Application No: BE/7/21/PL
Site Address: 377-379 Chichester Road Bersted PO21 5AT
Description of works: Demolition of outbuilding & change of use of redundant shop to 3 No. two bedroom flats, associated parking & gardens. This site is in CIL Zone 4 (Zero Rated) & may affect the setting of a listed building.

OWQC34245

Drawing: Block and site layout plan- (1:200@A3)

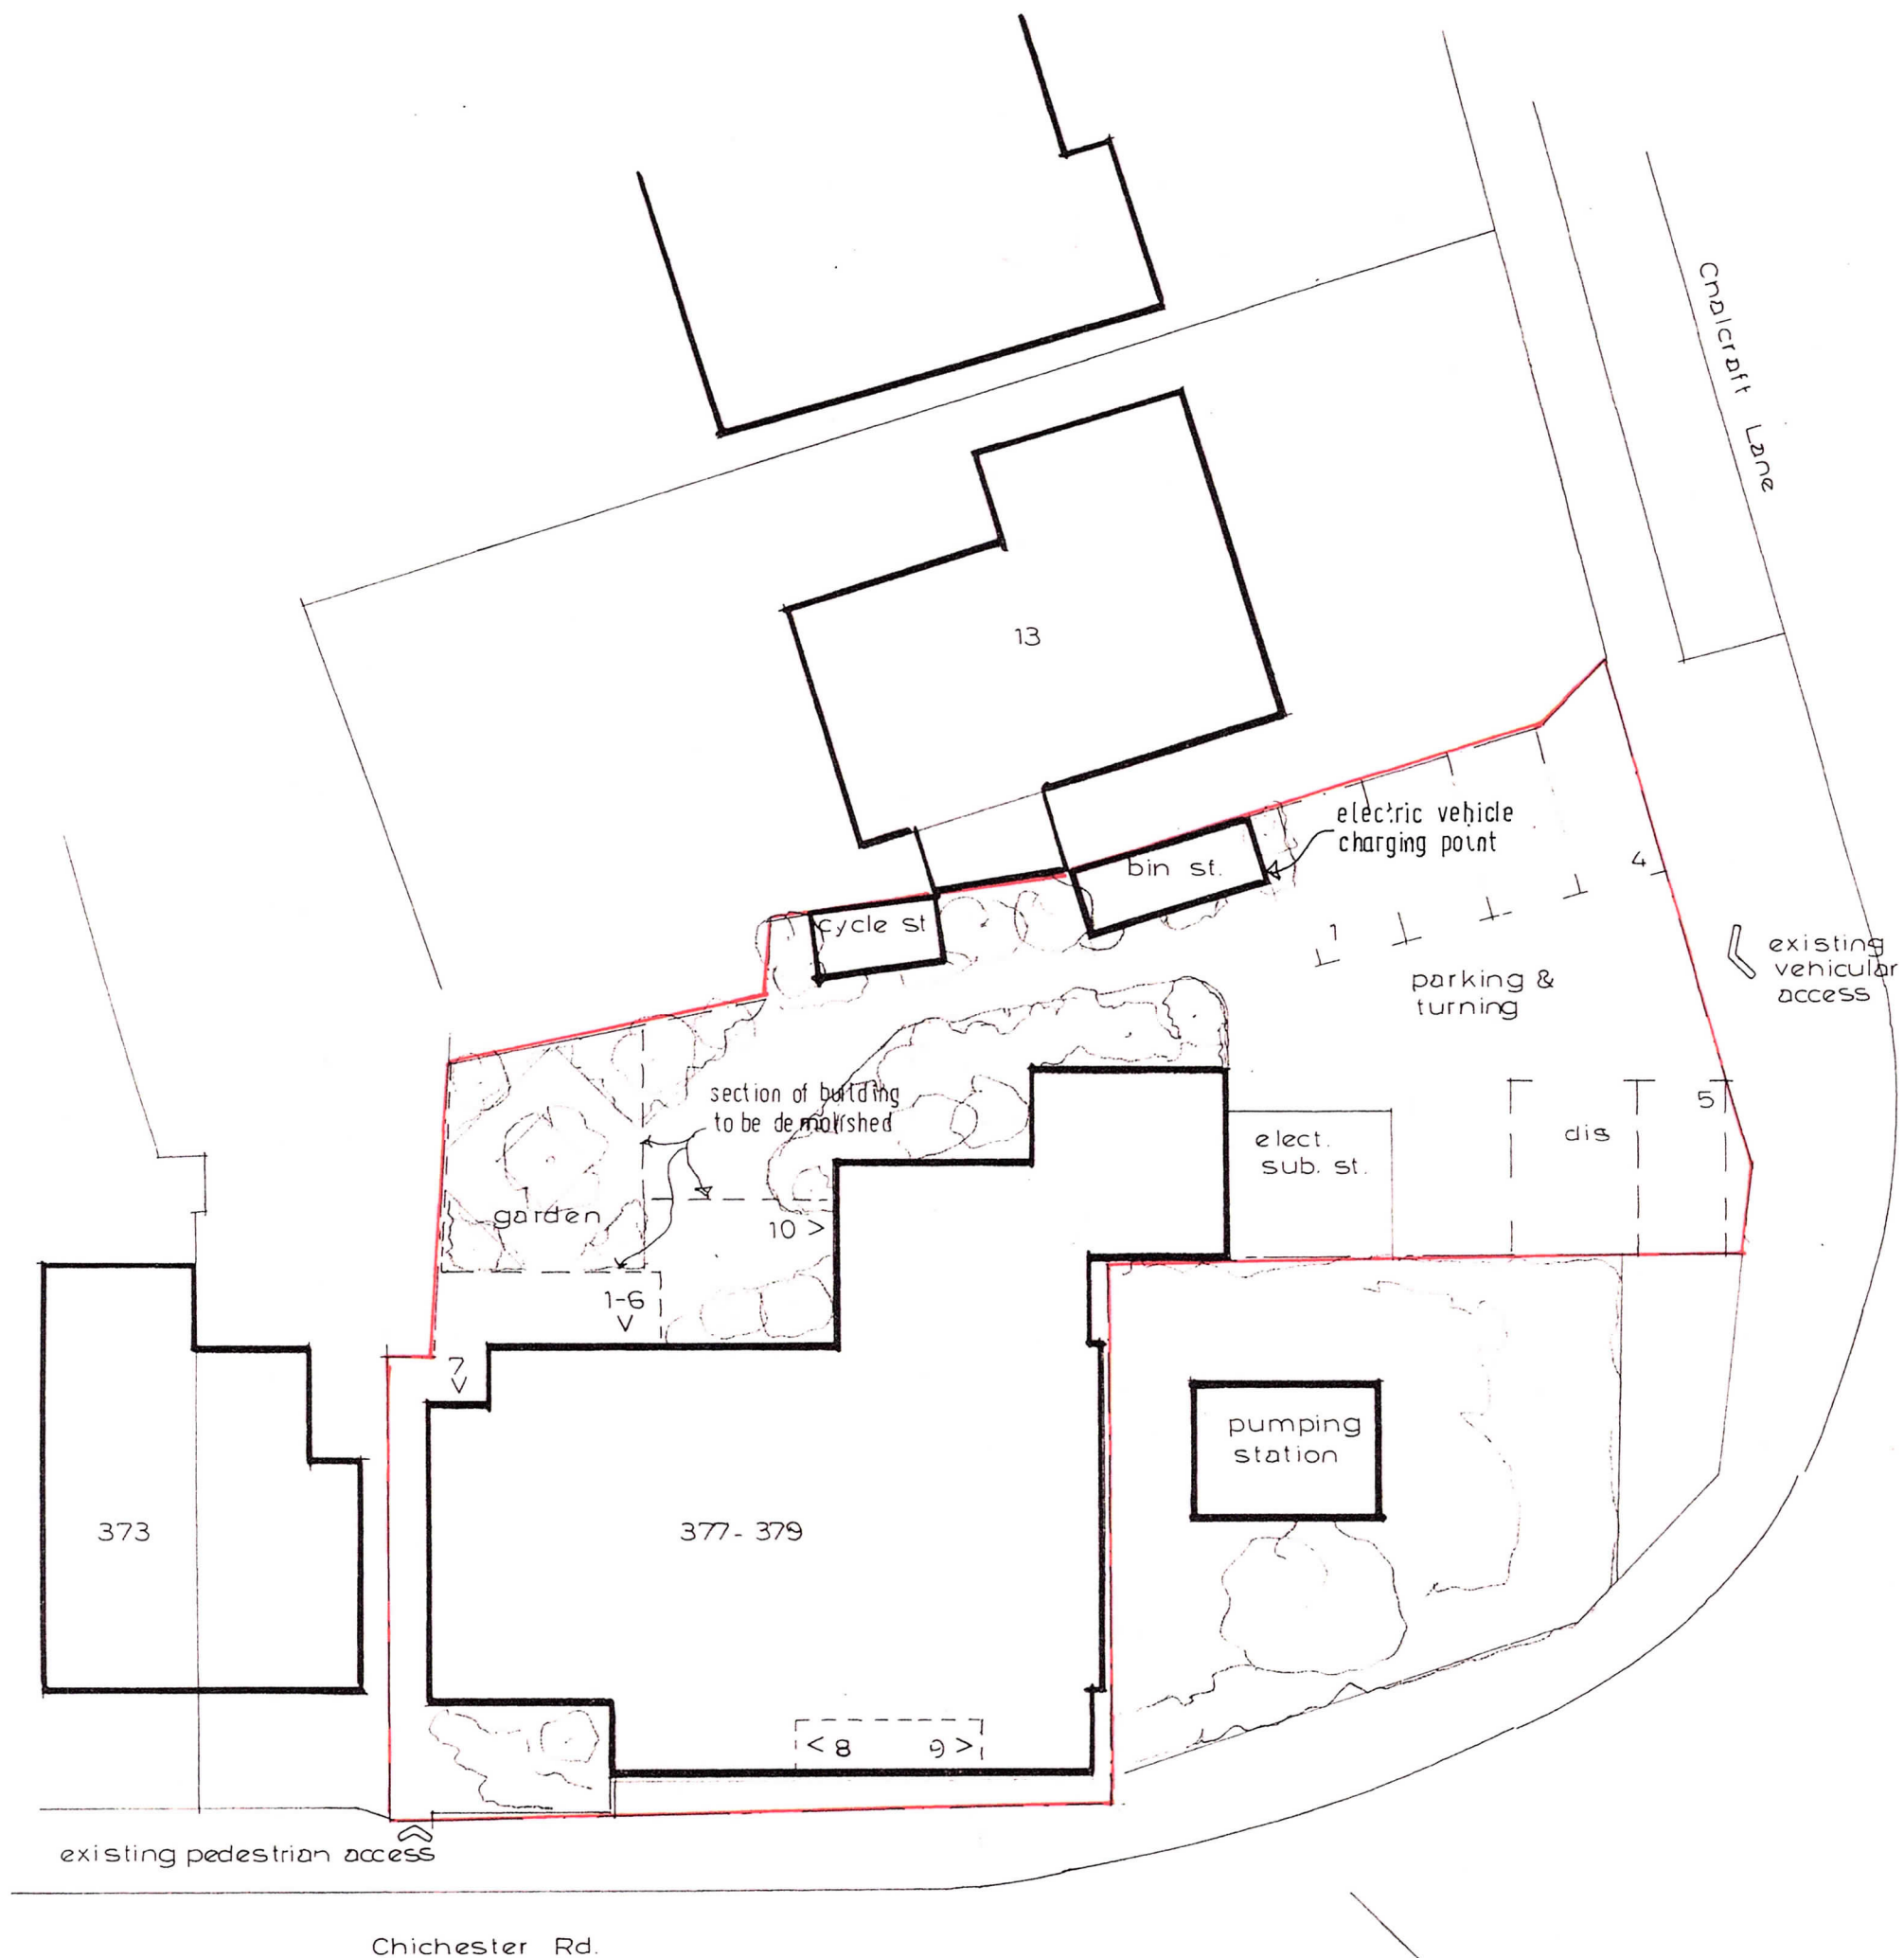
NO OBJECTION but make the following comments: - The effect of on street parking should be considered as this development is near a junction and mini roundabouts on the Chichester road.
